**Consultation Response from KC,
Highways Development Management****2024/92699 rear of, 51, Turnshaw Road, Kirkburton, Huddersfield, HD8 0TH****Erection of one dwelling and associated works****Date Responded: 18-12-2024.****Responding Officer: Mark Berry.****Responding Ref: 12-49-7.**

This application seeks approval to the erection of a 3 bedroomed detached dwelling on land to the rear 51, Turnshaw Road.

SITE PLAN
1:200@A3

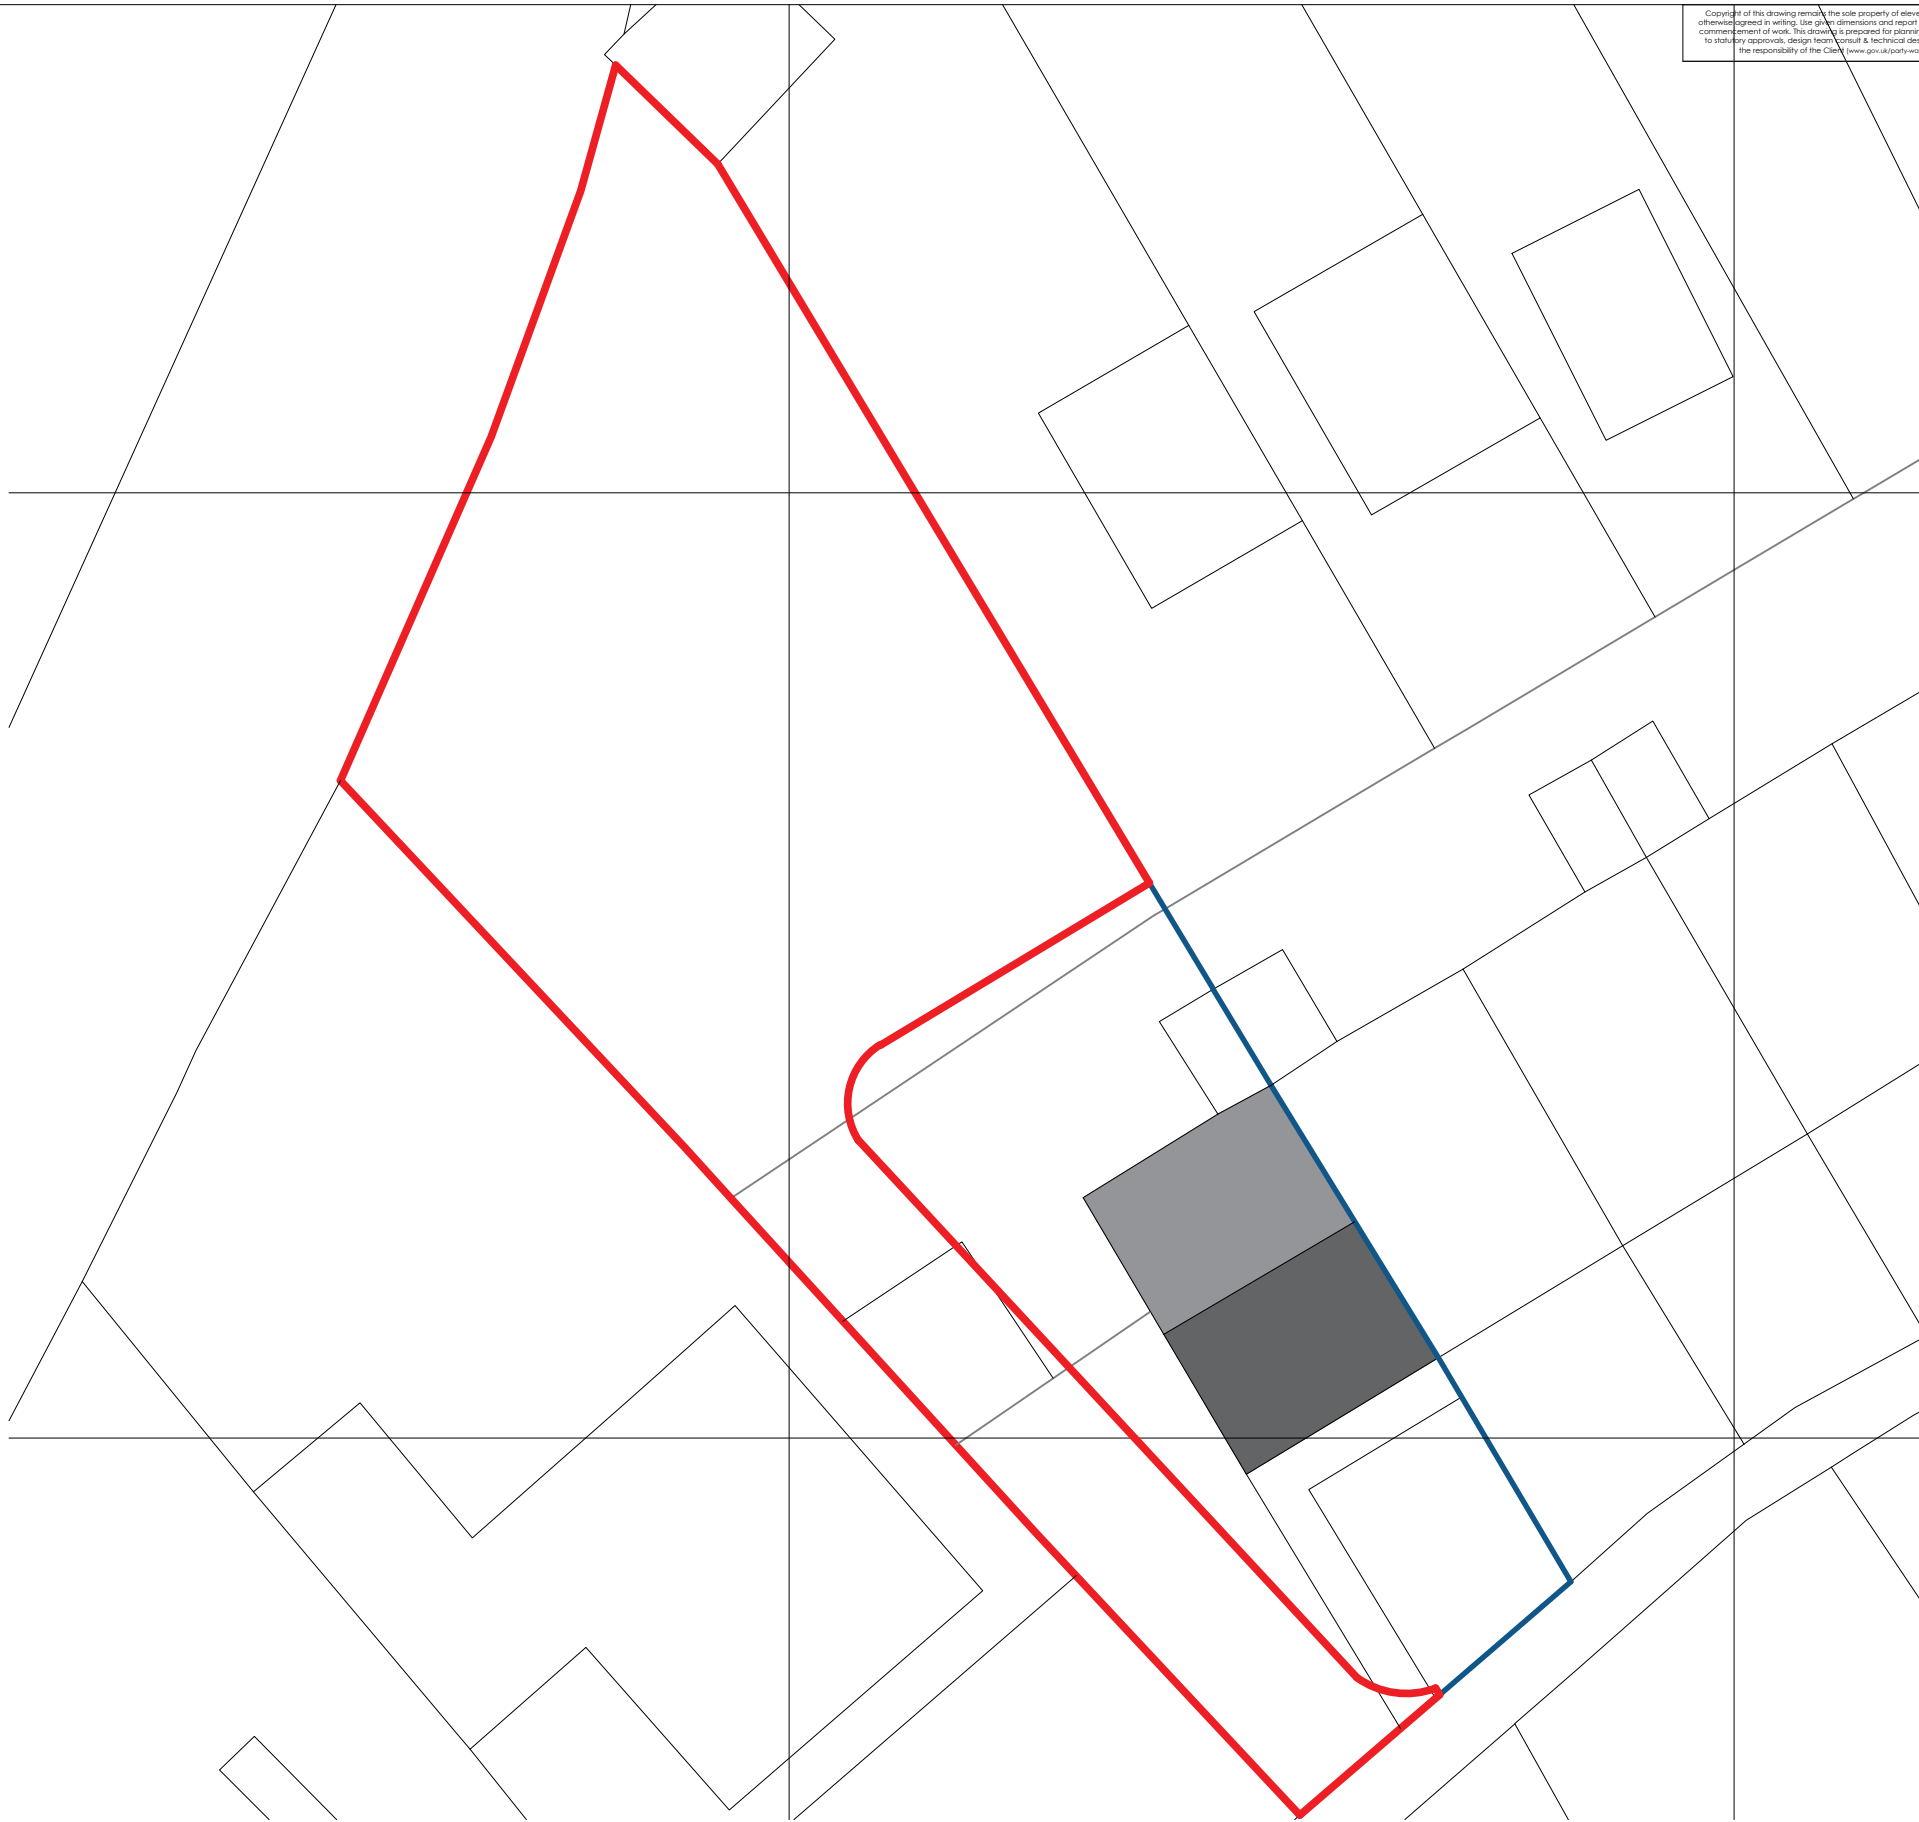
1, The width of the proposed shared driveway does not allow sufficient space at just 3.7m to allow turning into the proposed parking spaces to the rear of the existing dwelling, 6 m is recommended.

2, The existing street lighting to the site frontage needs to be shown to be re-sited.

3, A bin collection point should be shown to be provided to enable bins from both dwellings to be presented on collection day without either obstructing the highway or proposed driveway.

4, The sight line to the east of the proposed access is incorrectly drawn and should be drawn to tie into the near side carriageway edge.
